Sewall Wetland Consulting, Inc.

January 24, 2019

RE: 5637 East Mercer Way - Parcel #1924059312

This letter is a response to questions in the ESA memorandums dated 10-17-19, regarding Parcel #1924059312

Wetland and Wetland Buffer Impact Site Plan

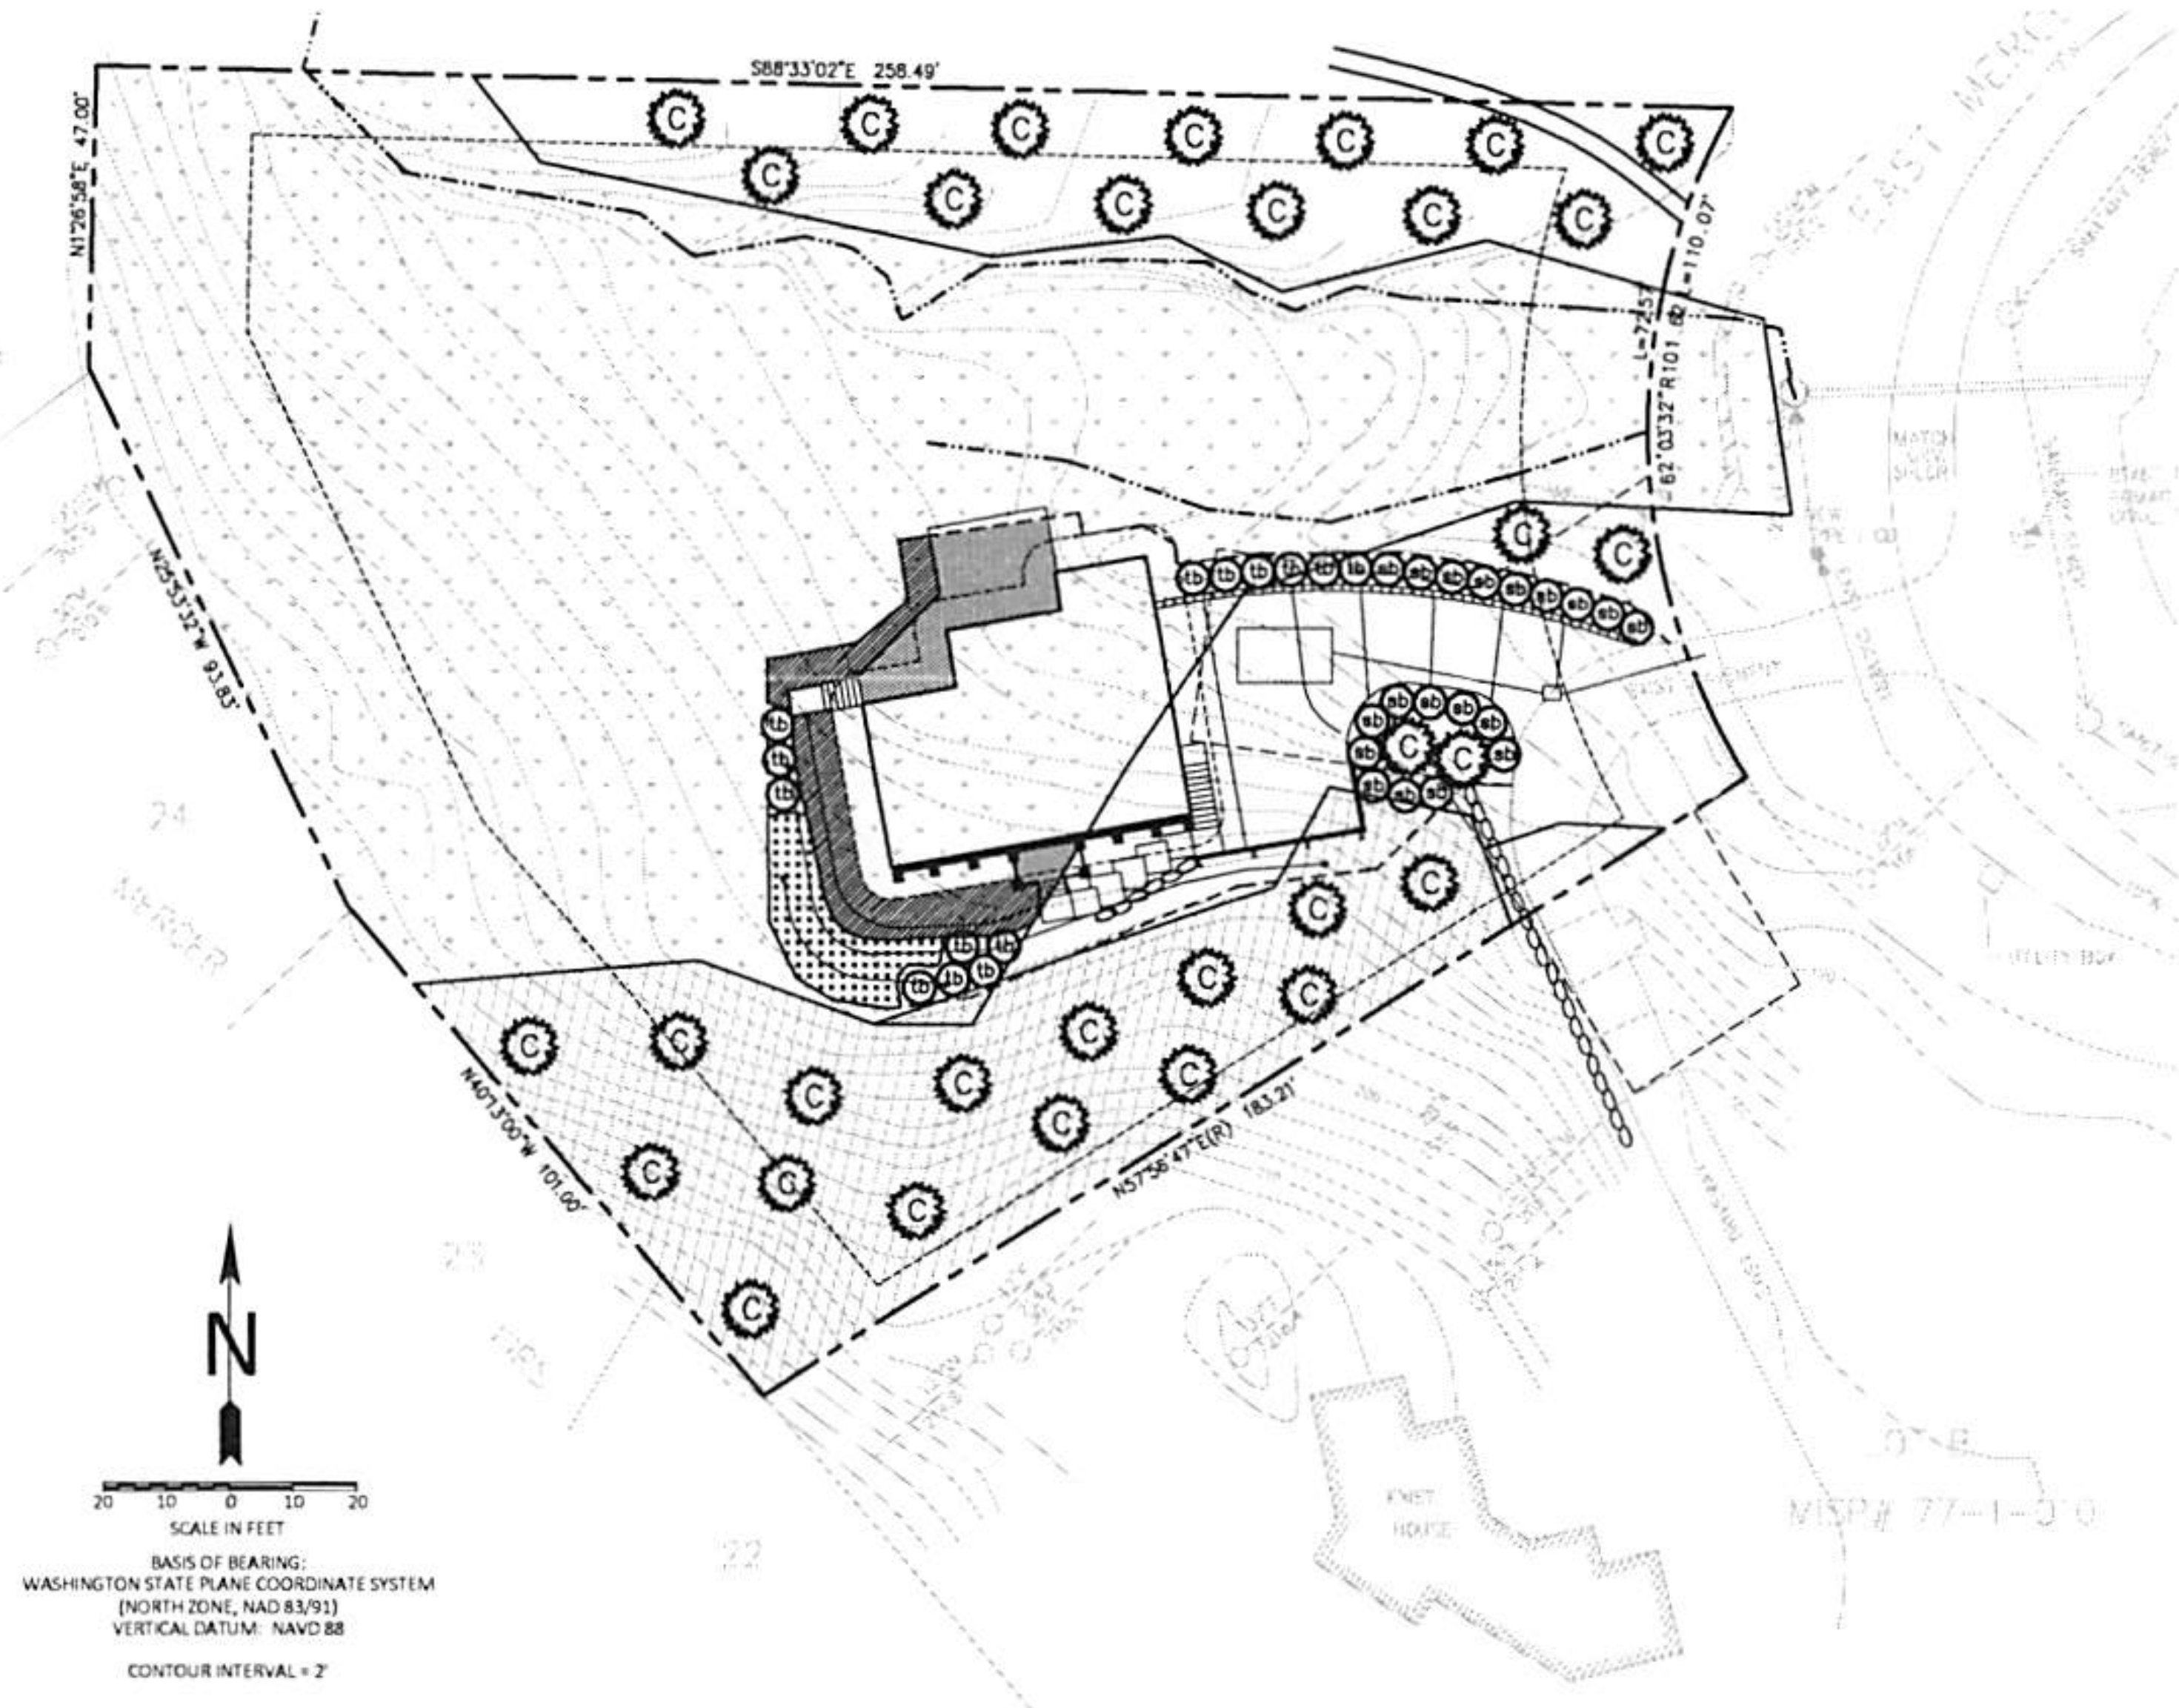
The March 8th CAR should indicate why the northeast corner of the building footprint is considered temporary and not permanent wetland impact.

Provide rationale to support the determination that decks will result in temporary, rather than permanent, wetland impacts;

3. The entire square footage of the northern deck should be considered as impact.

The applicant should provide detailed discussion and associated impact calculations, if applicable, of the
proposed excavation and grading activities. Grading should be designated as permanent wetland impact
and mitigated appropriately.

If the area encompassed by the perimeter fence or wall will be permanently disturbed, then appropriate
mitigation should be implemented based on the impact area.

8. A house maintenance area should be calculated and mitigated.

An additional offset or paper buffer of 5 feet from the maintenance area is appropriate; impacts should be calculated and mitigation implemented.

10. Recalculate buffer impacts applying the 50-foot wetland buffer.

11. Include the northern retaining wall in the impact area calculation.

<u>Response</u>: The area of the northeast corner of the site is now considered a permanent impact on the attached revised mitigation plan.

Response: Although we are proposing to replant the area under the decks, for the purpose of the impact calculations, we now are including

the decks as an impact. This area will now be replanted with slough sedge as a mitigation action

<u>Response</u>: As described in the previous response, this area is now considered an impact as requested.

<u>Response</u>: As requested, all structures and grading are now considered a permanent impacts as shown on the attached Wetland and Buffer Impact Site plan dated revised 12-17-18.

<u>Response</u>: The retaining wall isnow considered a permanent impact.

Response: A 5' BSBL area has been calculated as an impact as requested.

<u>Response</u>: A 5' BSBL area has been calculated as an impact as requested.

Response: The total wetland buffer impact area using 50' has been calculated as requested, and results in 3,479sf of buffer impact.

Response: The northern wall has been calculated as a permanent impact.

### Planting Plan, Notes, Details, & Monitoring Plan

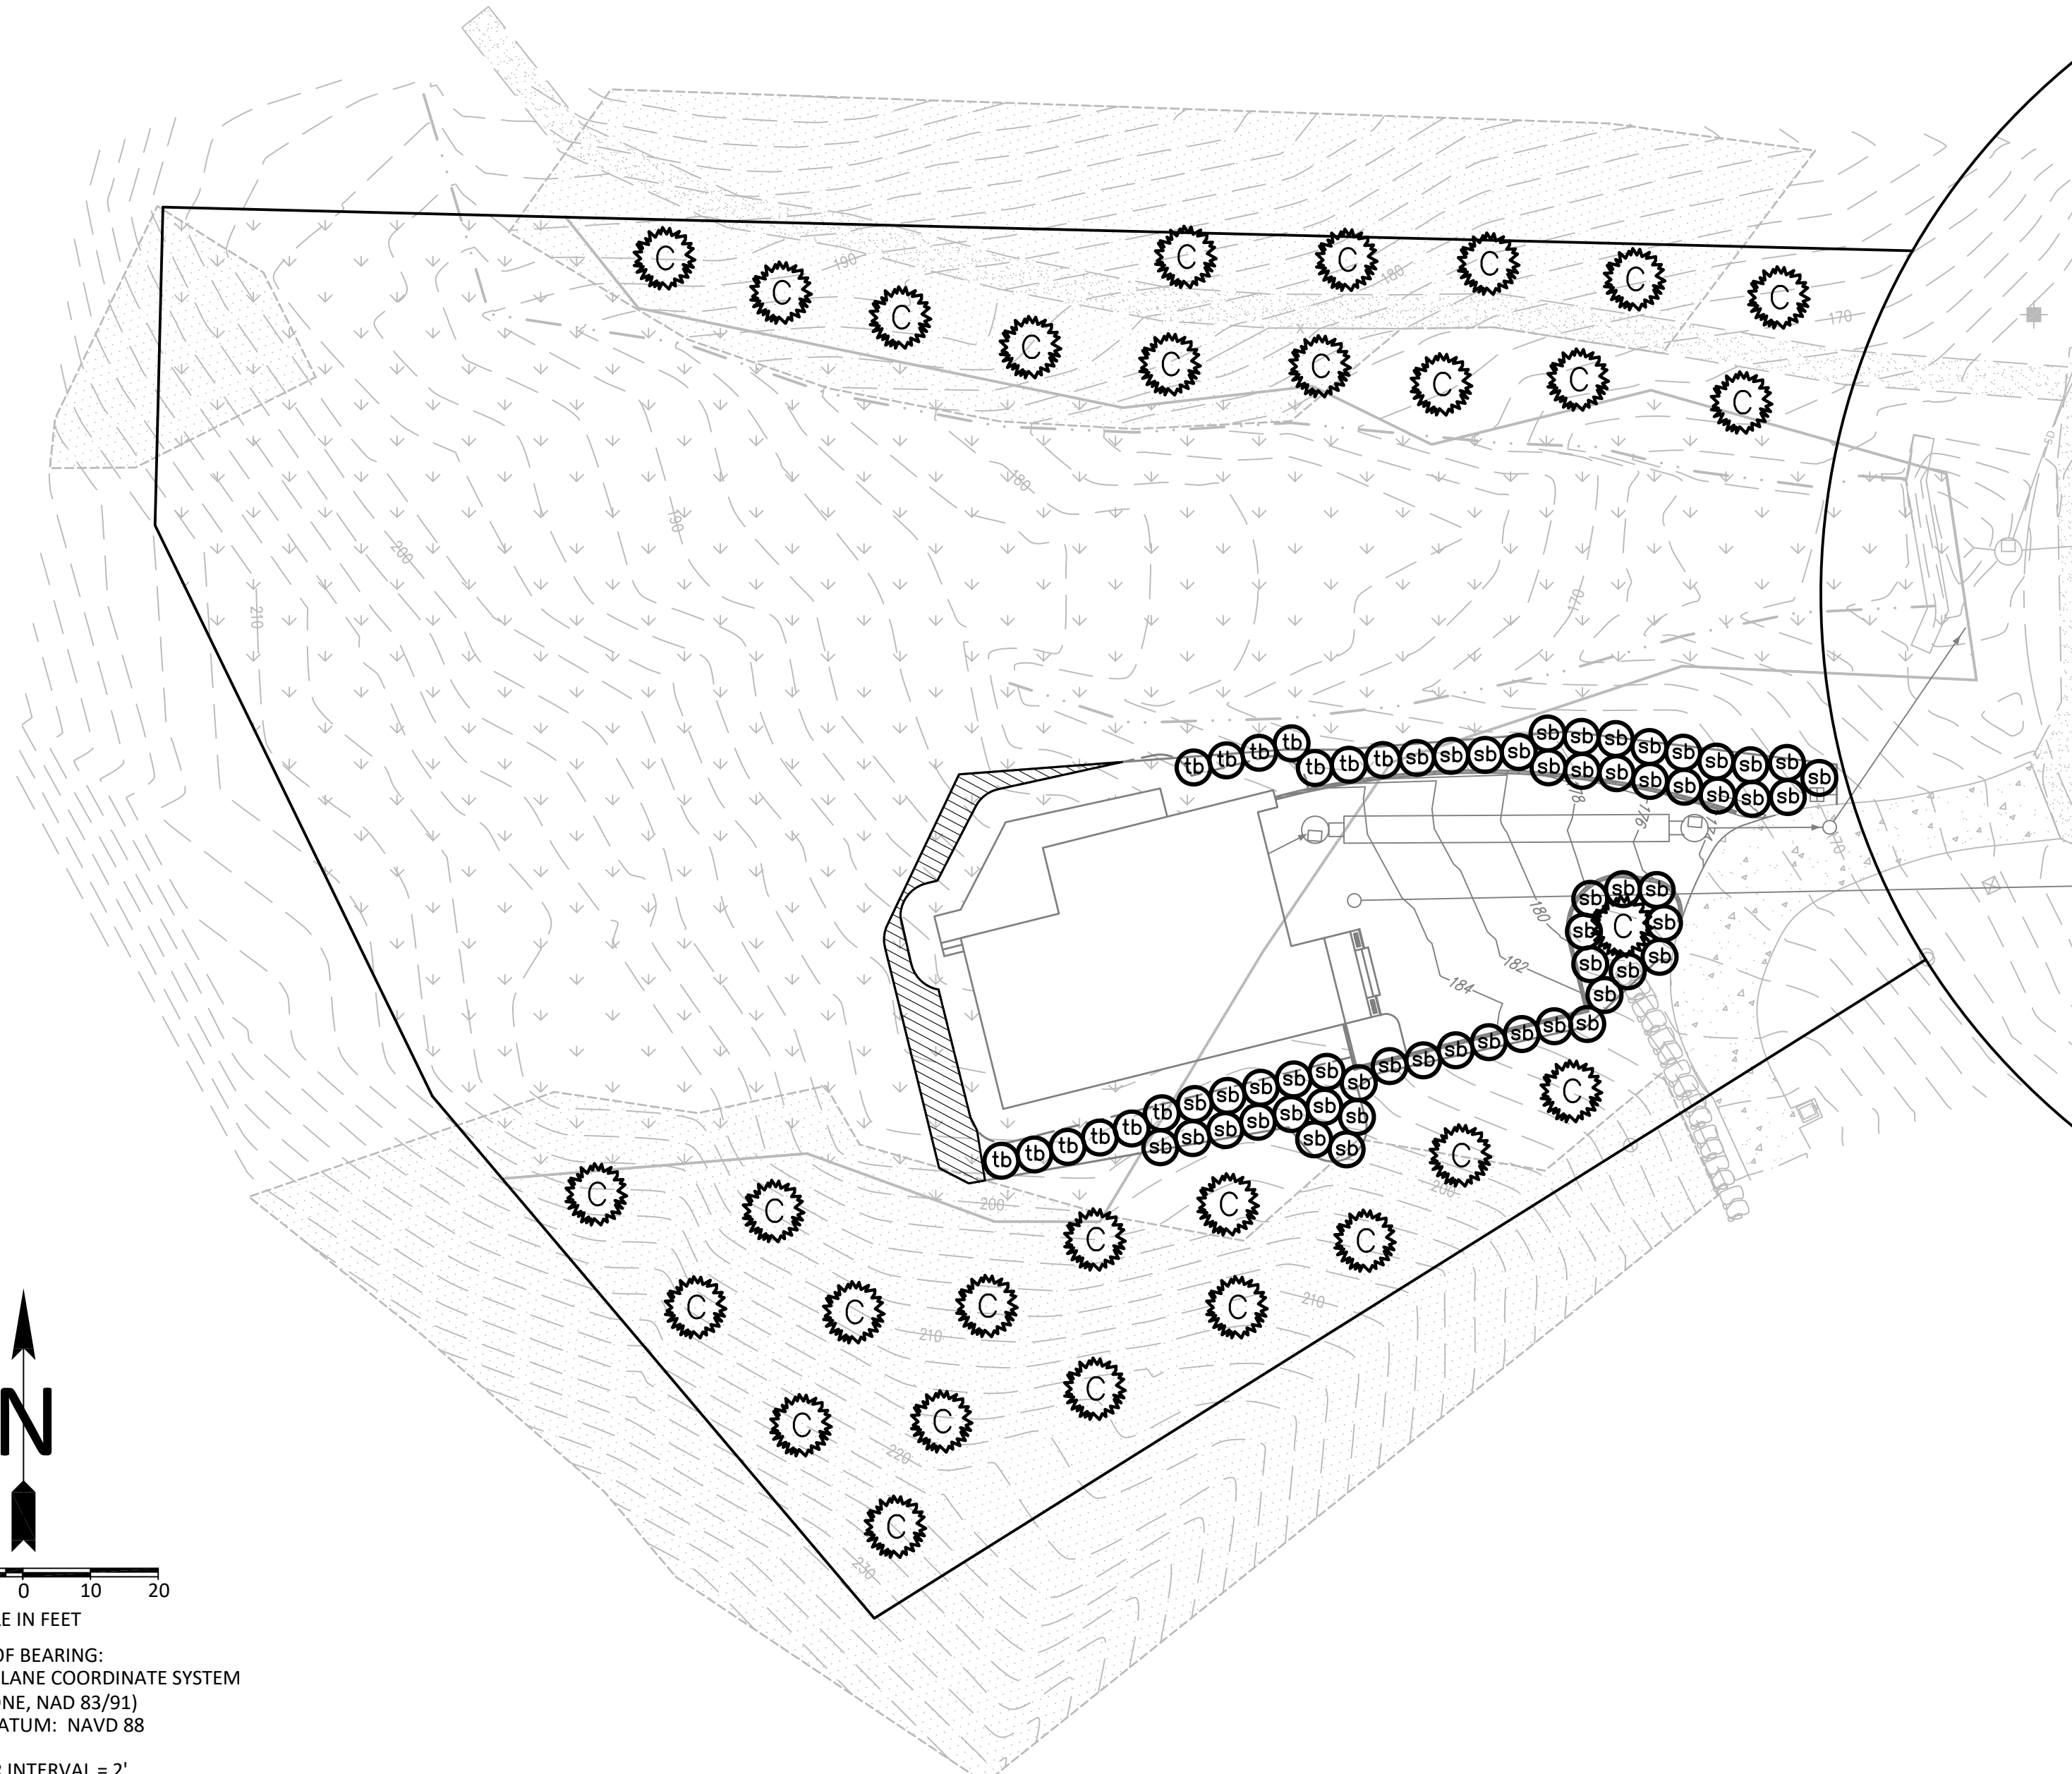
14. Mitigation discussion within the CAR should clarify the type of onsite mitigation.

- 2. Purchase of off-site credits from the King County Mitigation Reserves program to compensate for permeant wetland impacts.
 - 15. Mitigate onsite to compensate for permanent buffer impacts.

<u>Response</u>: The mitigation for the project will consist of two actions;

1. On-site buffer enhancement to include under planting the existing buffer with conifers, as well as replanting areas that are graded

and under the elevated decks. This is depicted on the attached Critical Area Enhancement Plan revised to 1-24-19.

<u>Response</u>: On-site wetland buffer enhancement includes removal of any blackberry and under planting with conifers as depicted on the attached Critical Area Enhancement Plan revised to 1-24-19.
